Reference: 6/2020/1463/FULL

Thank you for making me aware of the planning and development application proposed for Maynard Place. Although I welcome the improvements to the property and surrounding area, these are my very real concerns about the redevelopment of this site.

Proposed Block Plan
1:500 @ A3

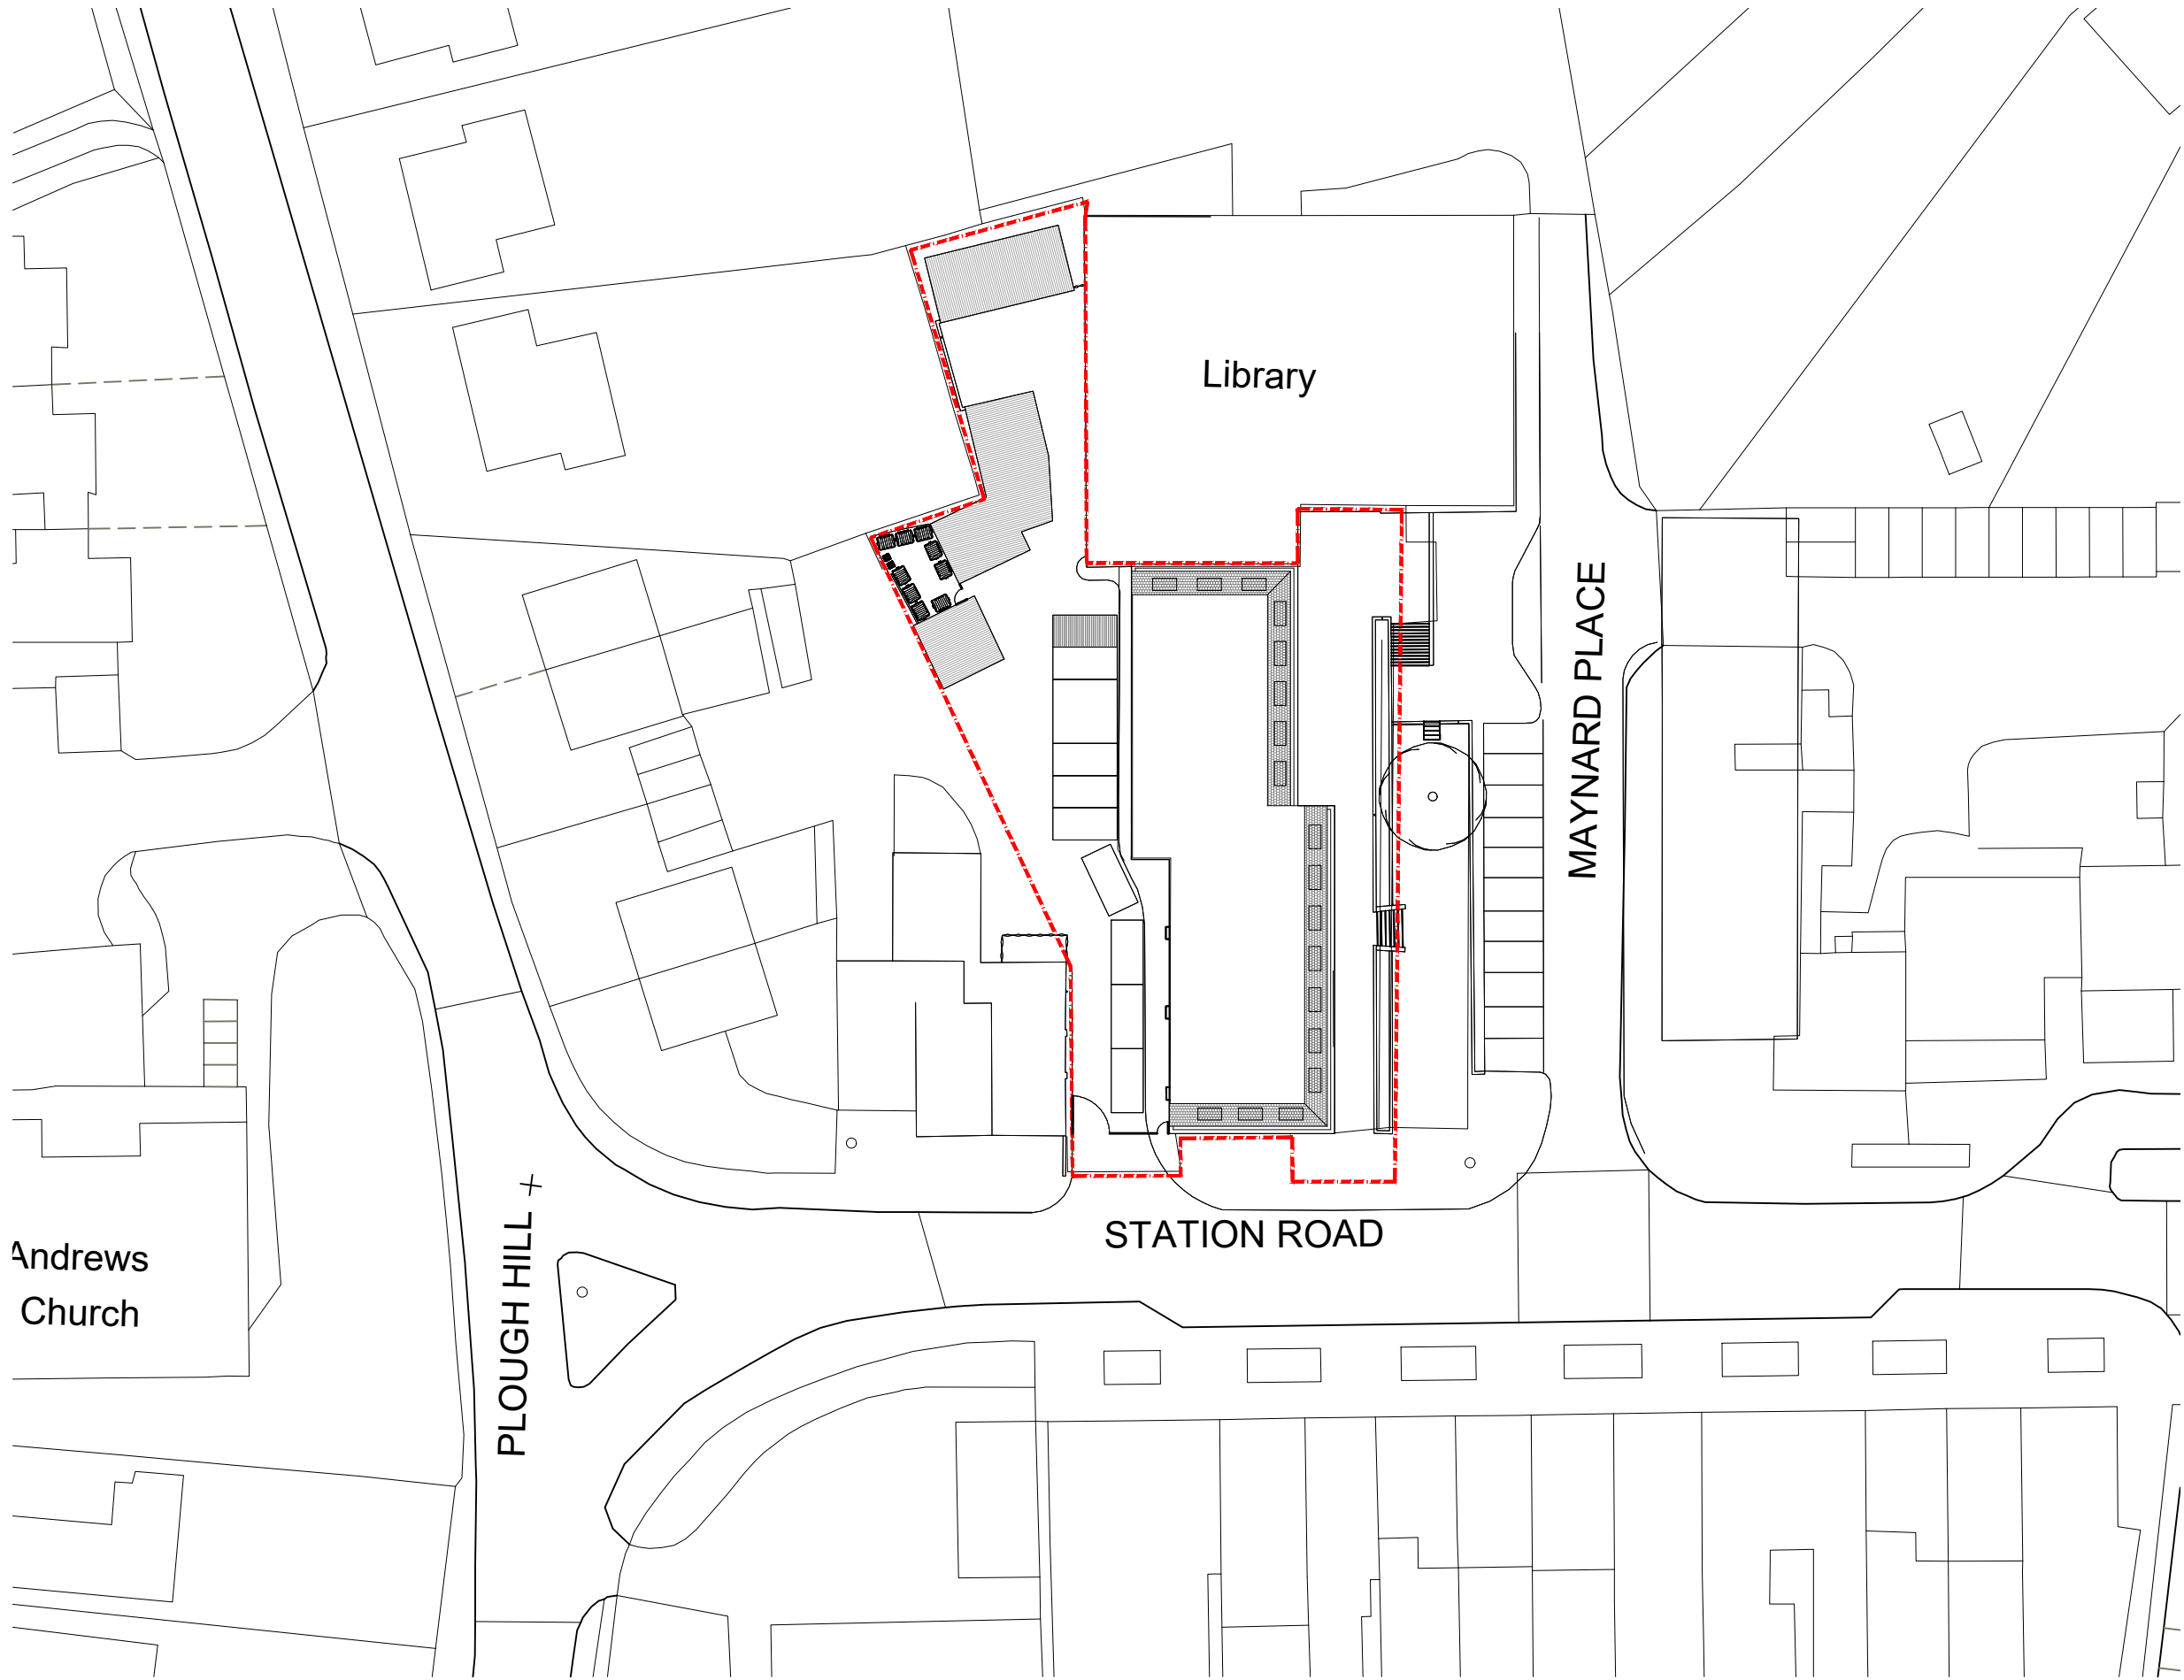
The garage is also positioned at an angle, opposite the existing parish council car parking spaces. The new proposal shows this space to be used for a bike store and visitors car parking space. Even if the garage were wide enough, the bike store or another parked car would prohibit me safely manoeuvring a car in or out of the garage.
